MMO Reference: DCO/2019/00005
Planning Inspectorate Reference: EN010117
Registration Identification Reference:20045232

Planning Act 2008, E.On Climate and Renewables UK Ltd, Proposed Rampion 2 Offshore Wind Farm Order

This document comprises the Marine Management Organisation's ("MMO") Principal Areas of Disagreement ("PAD") in respect of the above Development Consent Order application ("DCO Application"), as requested by the Examining Board in the Rule of 9 letter dated 20 September 2023.

Figure 6– INSPIRE Light Noise modelling for 141 dB SEL pile strike, with various mitigations

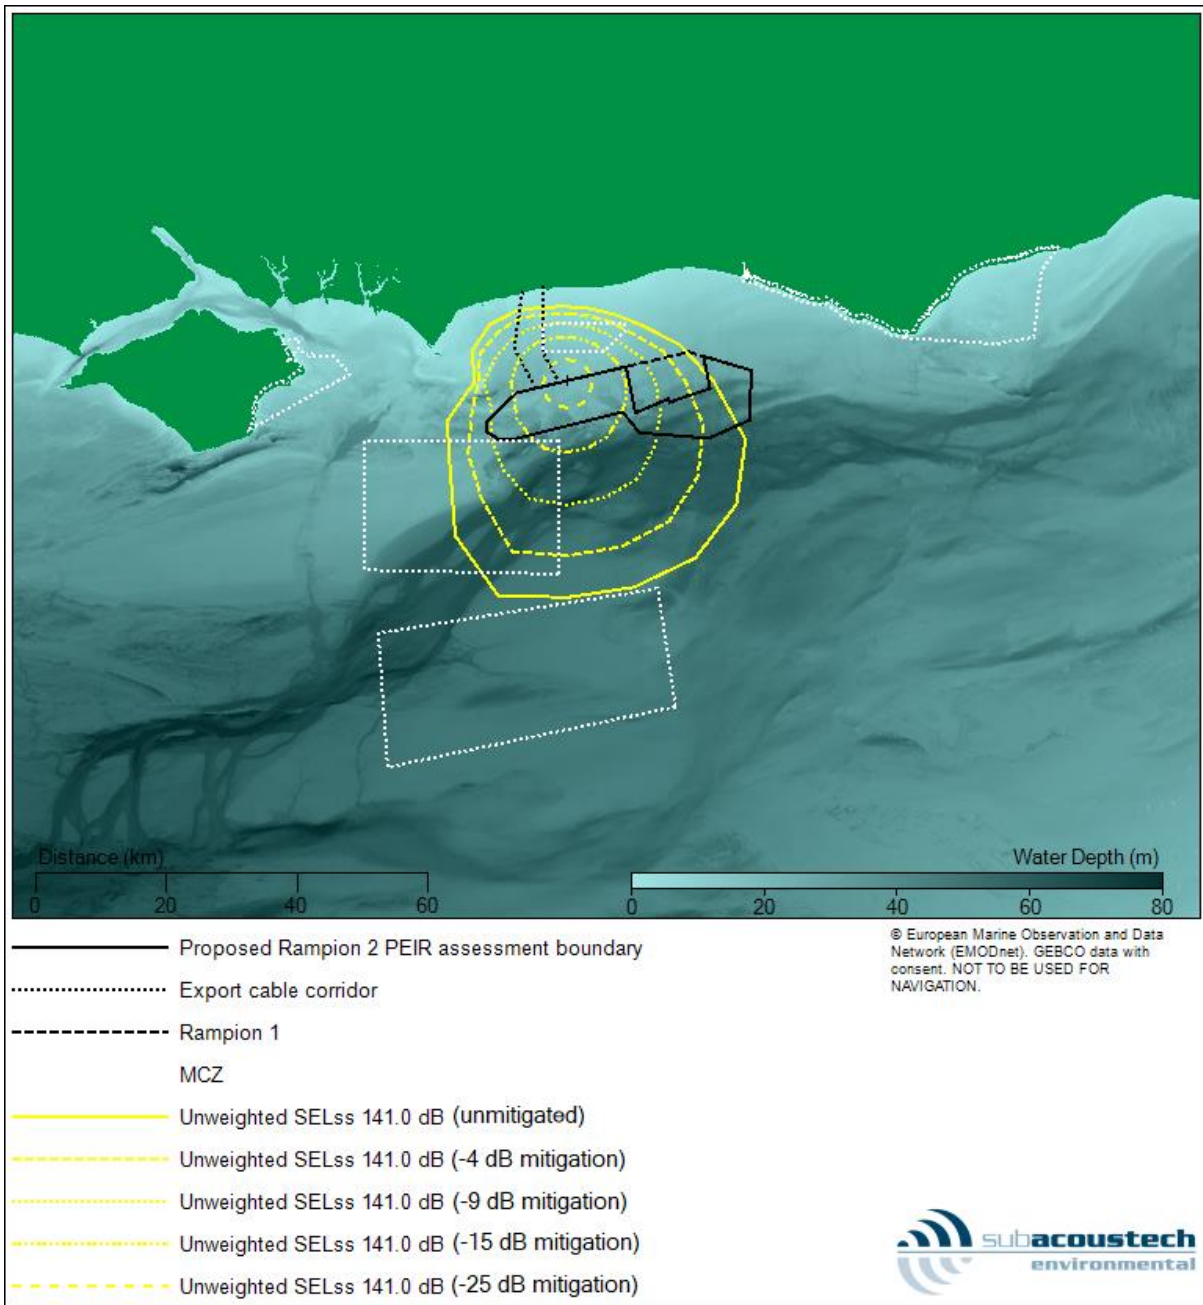
Black seabream UWN disturbance threshold	A threshold approach has been based on a threshold of 141dB re 1µPa SELss as defined by Kastelein et al., (2017). This has also been used to form the basis of mitigation.	MMO does not consider a SELss of 141 dB re 1 mPa ² s used for a 44cm captive seabass to be an appropriate or conservative threshold. MMO understands there was no agreement between MMO, Natural England (NE) and the Applicant on a noise threshold or proxy species for black seabream prior to submission of the Application. If the Applicant wants to pursue a noise threshold route the MMO would expect to see more noise modelling based on the 135 dB threshold. However, even if this is provided the MMO is unlikely	MMO believes this may not be fully resolved during Examination but is hopeful that the Applicant will provide the modelling and further discussions can take place. MMO hopes these concerns will be resolved during Examination, noting they have not been resolved through pre examination.

Figure 5-15 Zoning Plan: Piling Restriction for July (illustrative Sequencing of Piling Activities)

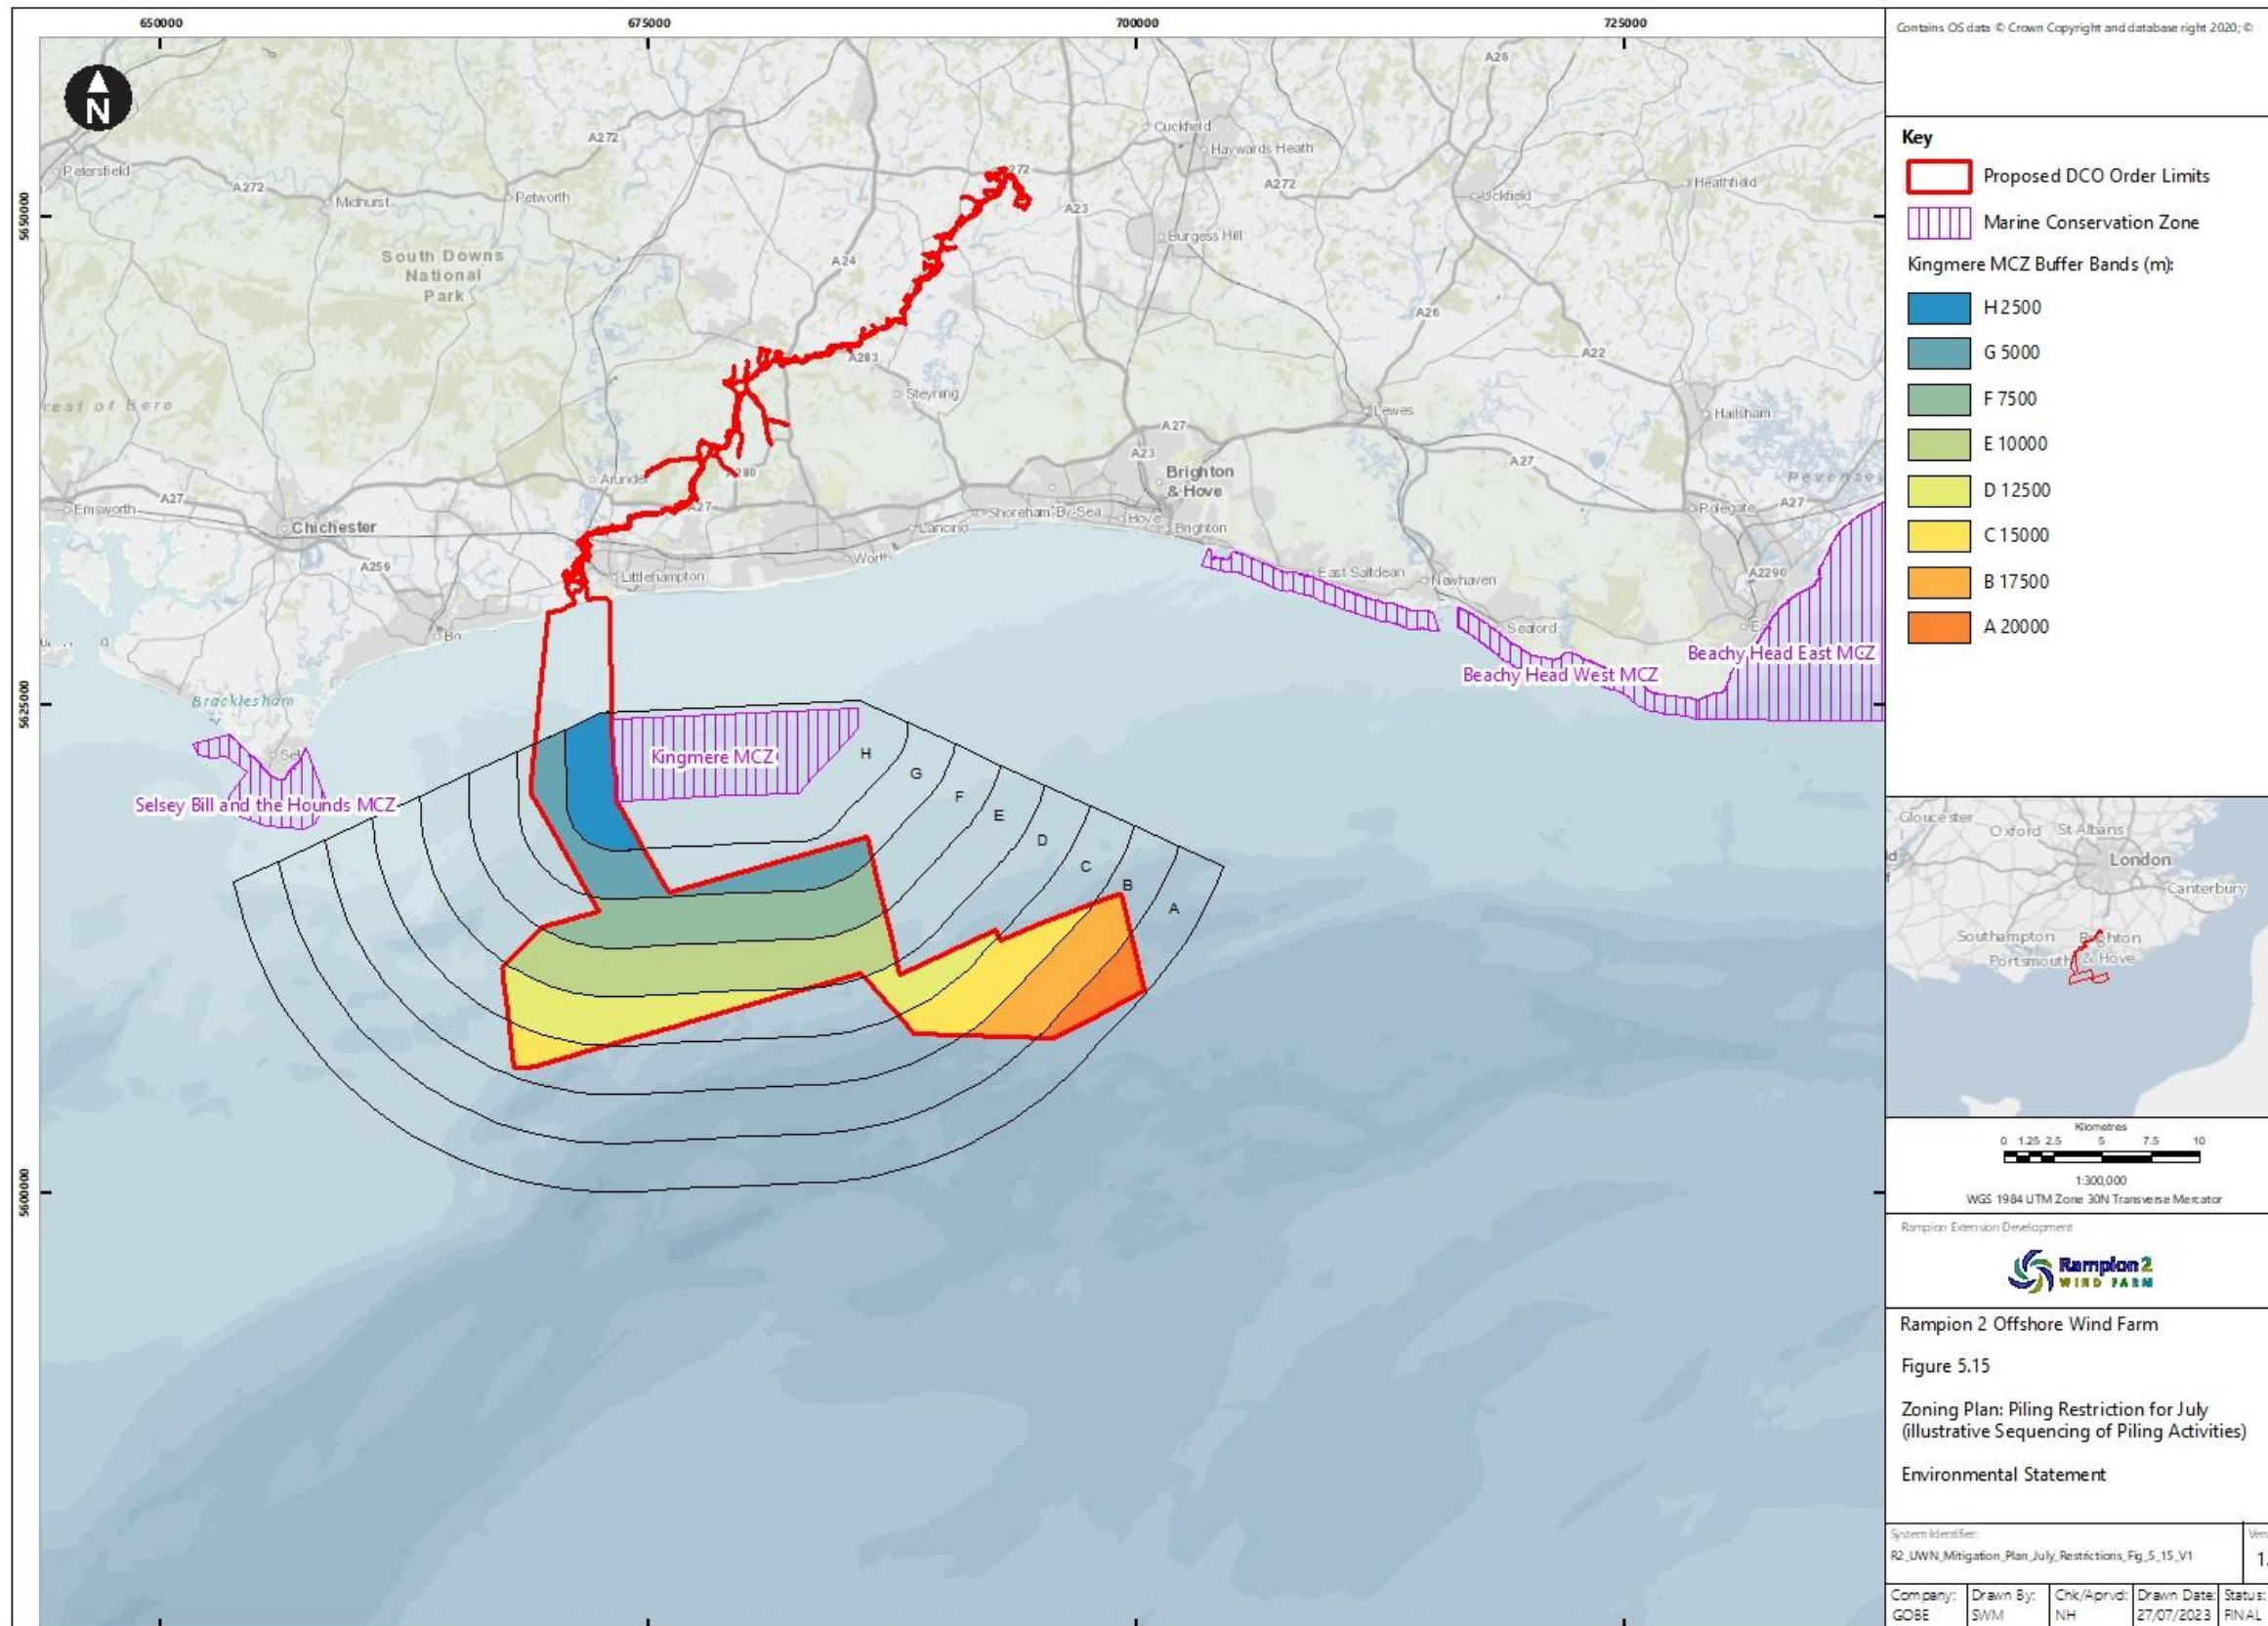
Noise abatement during – exclusion of July	It is not clear why July has been treated separately within the Applicant's proposed mitigation zoning plan. Black seabream are at their most sensitive when undertaking spawning and guarding their nests, and as a result, the conservation objectives of the Kingmere Marine Conservation Zone (MCZ) are of heightened importance during the spawning period. As we have clear evidence that black seabream continues to	July should be included in the defined mitigation period for the zoning plan however as above any mitigation must have the correct modelling.	MMO believes this may not be fully resolved during Examination but is hopeful that the Applicant will provide the updates and further discussions can take place. MMO hopes these concerns will be resolved during Examination, noting they have not been resolved through pre examination.

spawn and maintain their nests into and during July, we must consider that July is part of the spawning period.		
Seasonal Piling Restriction	The MMO considers it necessary for a seasonal piling restriction to be implemented in order to prevent disturbance to spawning herring and their eggs and larvae at the Downs spawning ground during the spawning period of 1st November to 31st January (inclusive).	This restriction may be subject to refinement, providing the additional UWN modelling (135Db) and further discussions on mitigation. However, at this time, the MMO considers that a seasonal piling restriction be implemented.	MMO believes this may not be fully resolved during Examination but is hopeful that the Applicant will provide the updates and further discussions can take place. MMO hopes these concerns will be resolved during Examination, noting they have not been resolved through pre examination.
